From: David Spring <David.Spring@arun.gov.uk>
Sent: 27 February 2020 09:13
To: Planning.Responses <Planning.Responses@arun.gov.uk>
Subject: FW: LU/2/20/PL - ext. of time to 20th March 2020

From: David Spring <David.Spring@arun.gov.uk>
Sent: Thursday, January 23, 2020 1:55:43 PM
[REDACTED]
Subject: LU/2/20/PL - Highways Comments

Please find the Highway comments attached. They are not objecting but do recommend a few conditions. One thing they would like changed is in terms of access, outlined below:

Block Plan

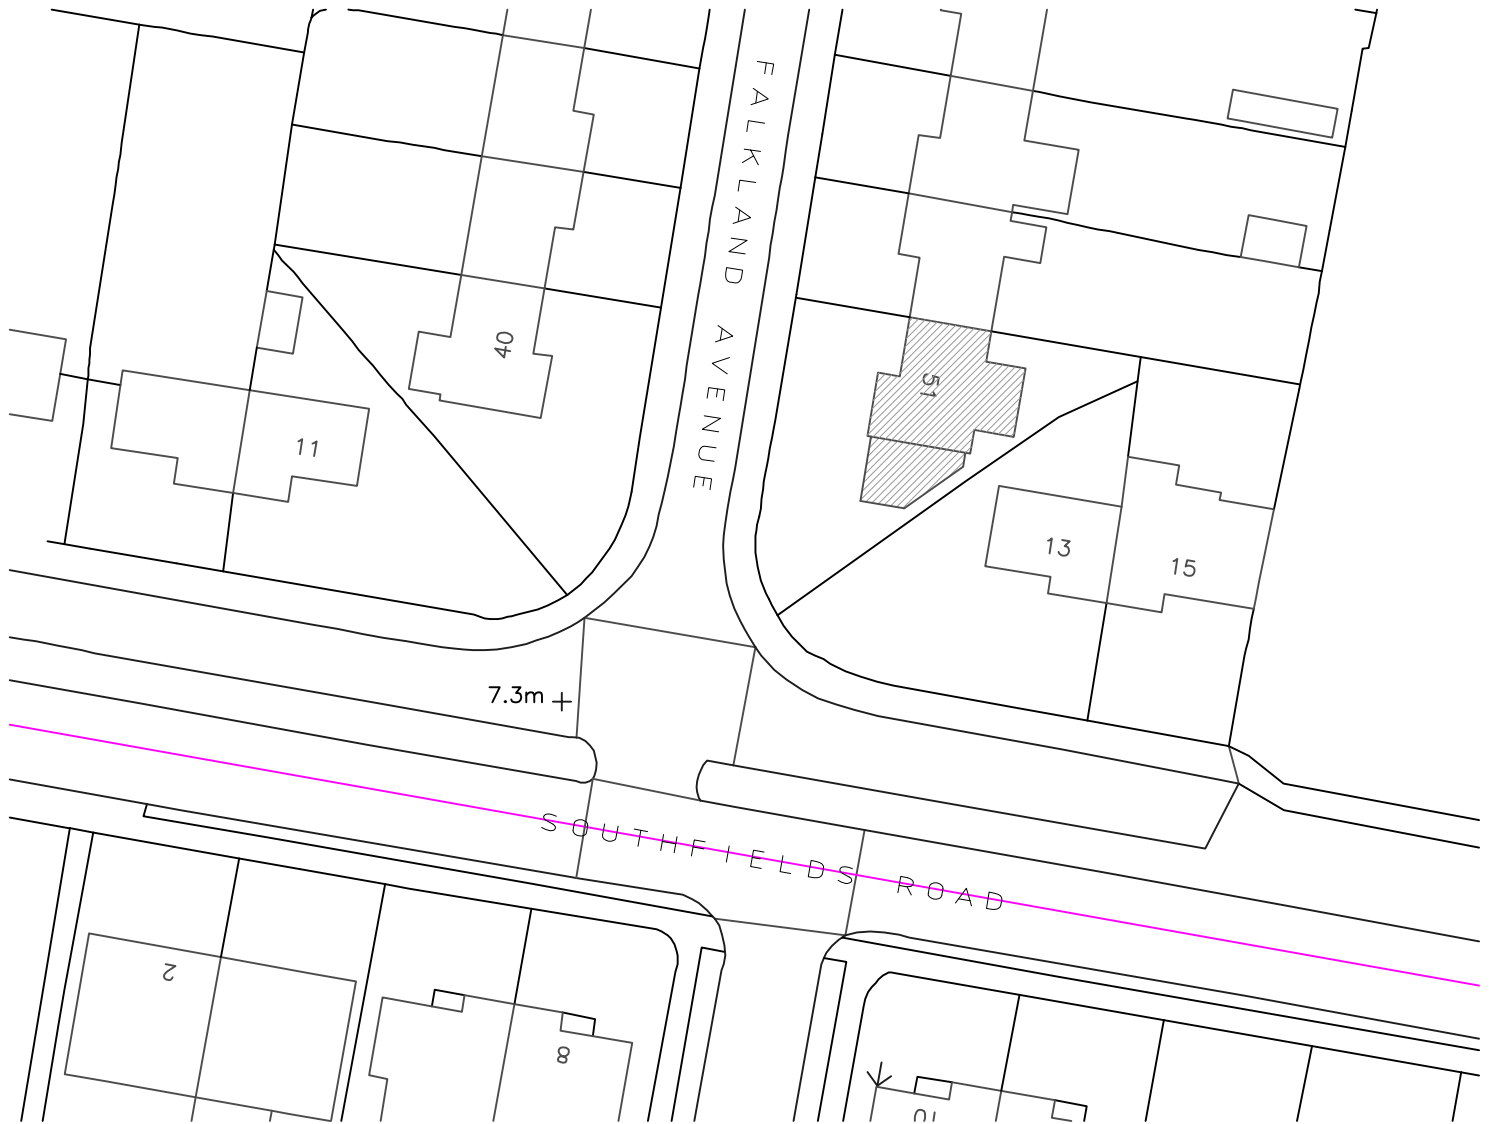
This proposal includes construction of two additional vehicle crossovers (VCO) to accommodate the proposed parking provision. I have consulted the Area Manager to provide their comments in relation to the proposed VCO. They have advised that rather than two separate VCOs, the full height kerb between the two proposed VCOs should be dropped, providing a wider, shared VCO. Any access works onto the public highway must be constructed under a licence obtained from WSCC Highways to a specification agreed with them'.

Could you send in an amended plan incorporating this wider single vehicle crossover please?

Ground Floor Plan @ 1:100

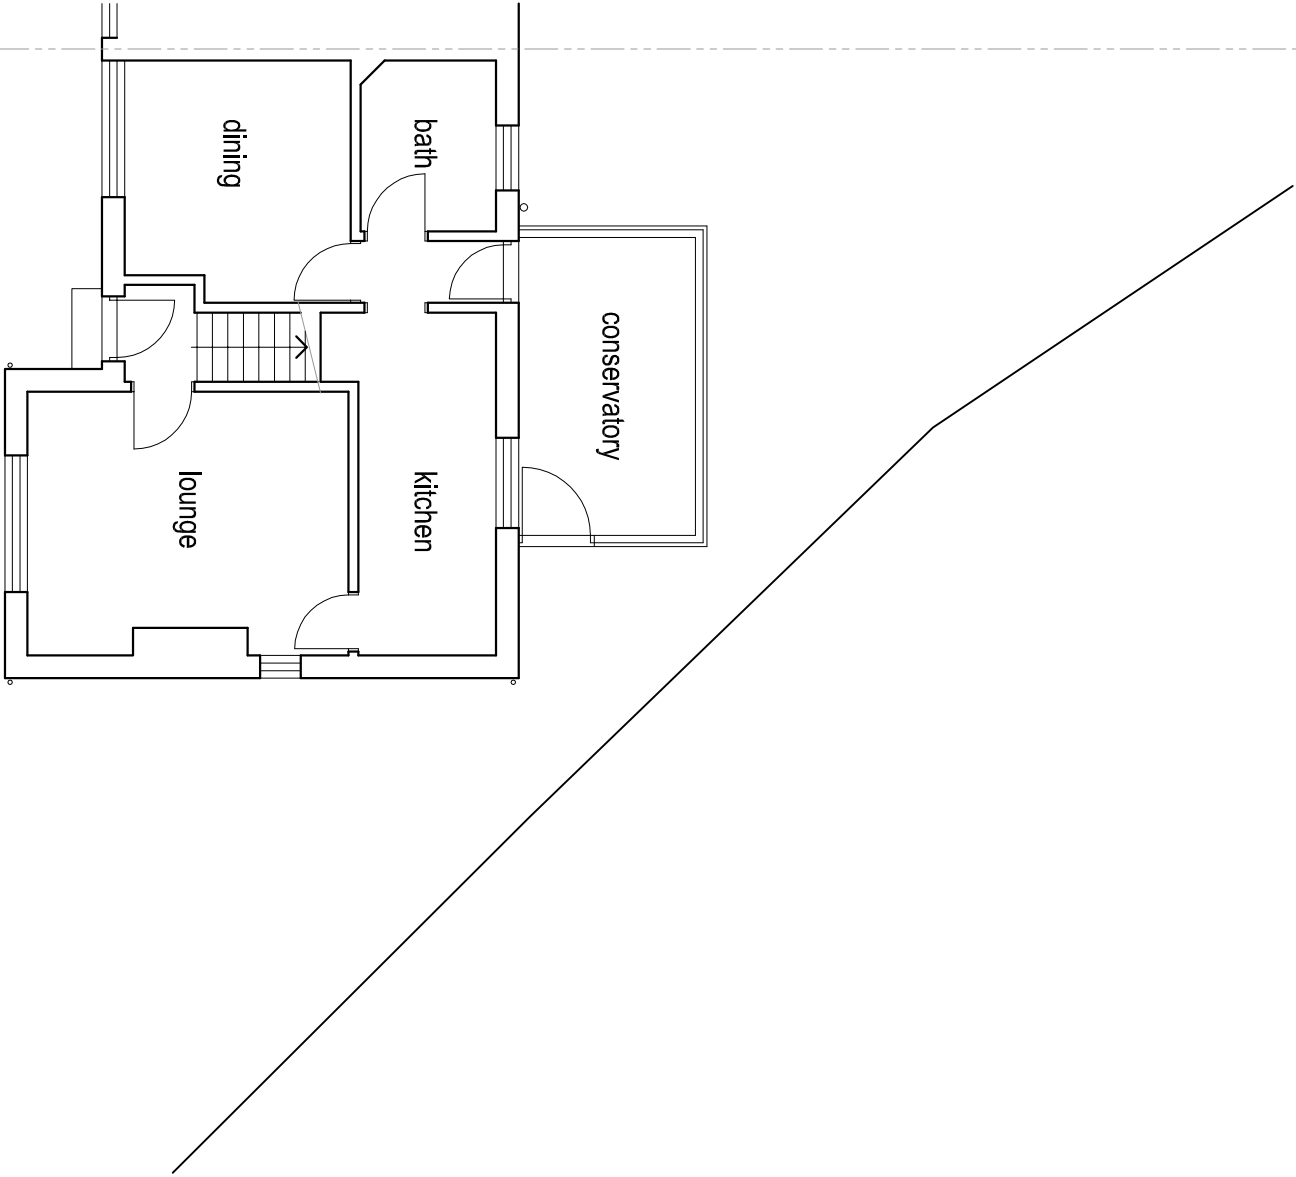
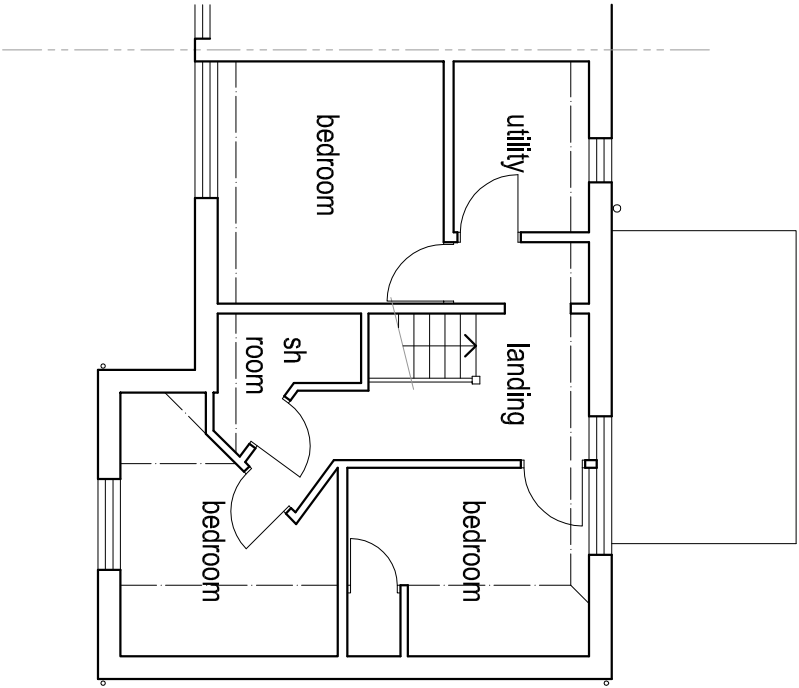
Unit 1: 39.5 sqm

Unit 2: 41.2 sqm

Unit 3: 38 sqm

Unit 1 & 2 would satisfy the requirements if there are occupied by 1 person each.

Unit 3 would need to be at least 58 sqm as it's 2 storey so it's 20sqm short of requirements.

On this basis the application will be refused.

Is it possible to amend the application to 2 No two bedroom flats at just over 61m sq each.
